Our Ref: BR/272/19/PL

21st October 2019

**Town & Country Planning Act 1990 (as amended)
Town and Country Planning (Development Management Procedure) (England) Order 2015
Application for Full Planning Permission**

Development	Replacement of existing failed balcony slabs together with the railings on like for like basis & repair canopy roof. This application affects the character & appearance of the Aldwick Road Conservation Area.
Location	Flats 5 & 6 Sussex Court Park Road Bognor Regis

Parsons Son & Basley
Sussex Court, Park Rd., B. Regis
LOCATION & SITE PLANS

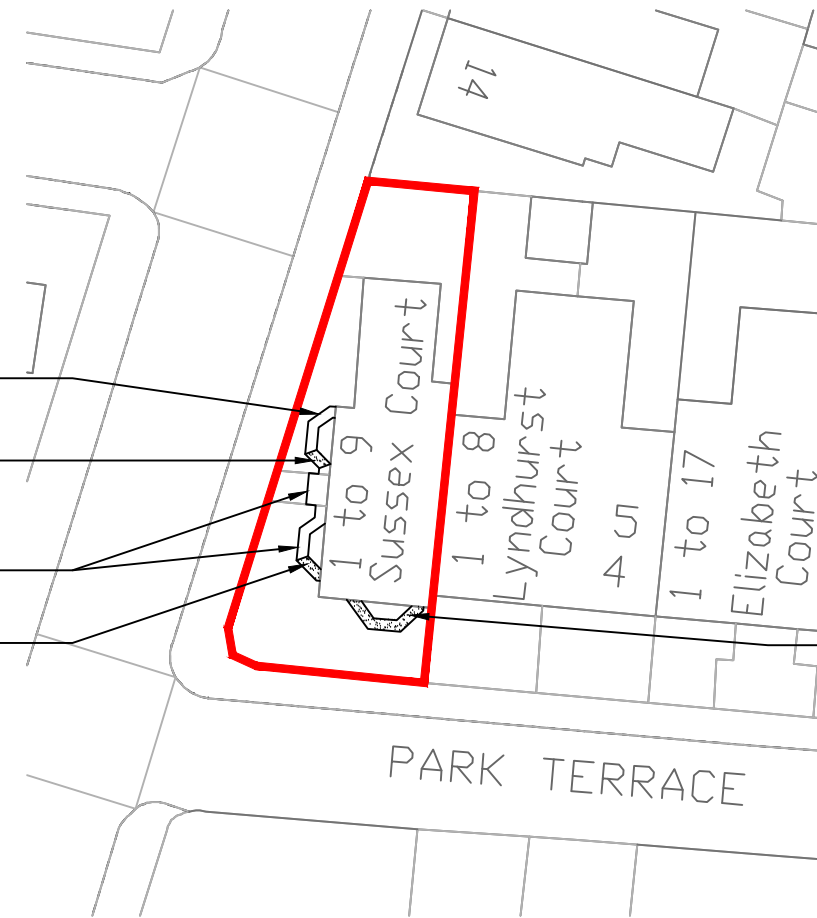
Please provide a north point on the location and site plan.

On the site plan, please clearly highlight the proposed works.
